Addendum No. 1

RE: Contract # C204369

Lee County (R-3830)

NC-42/SR-1579 (BROADWAY RD) FROM US-421 IN SANFORD TO SR-1538 (E HARRINGTON AVE) IN BROADWAY

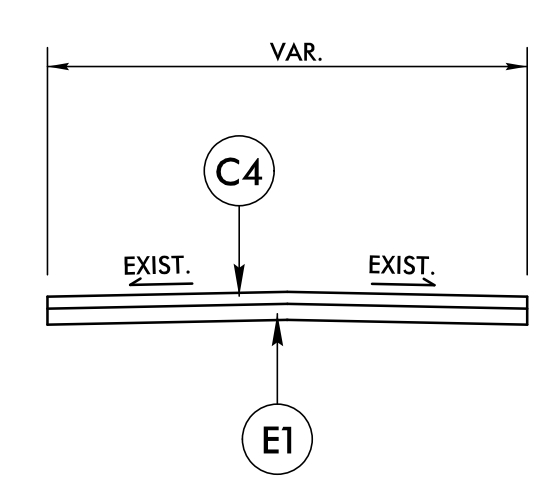
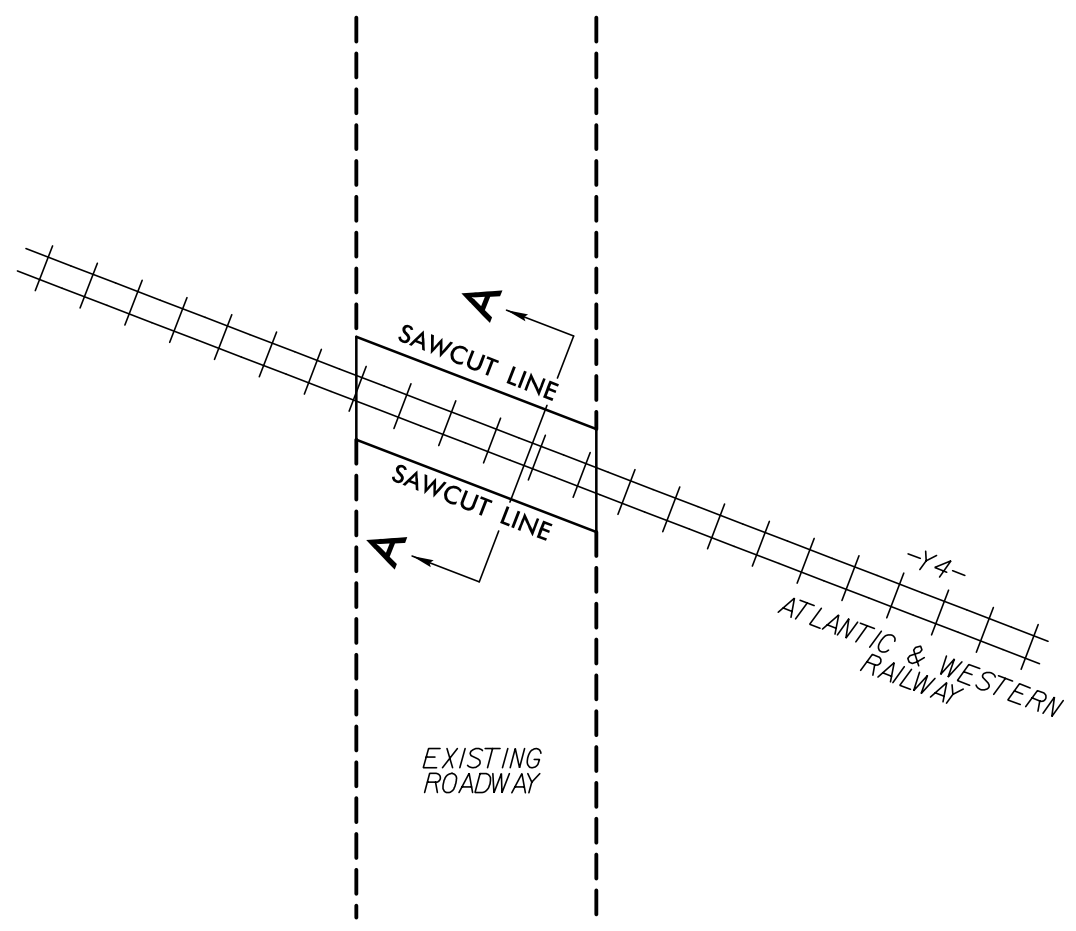
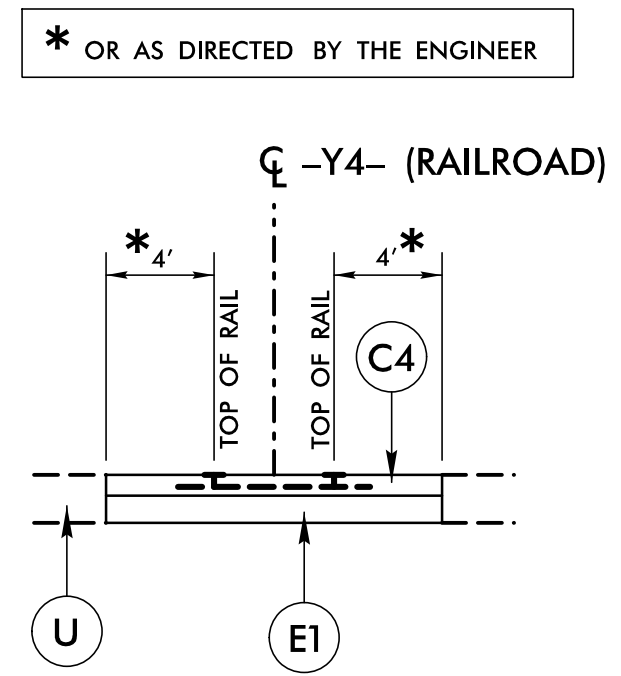
Sheet No.	Revision
2A-10	Detail for Railroad Crossings added
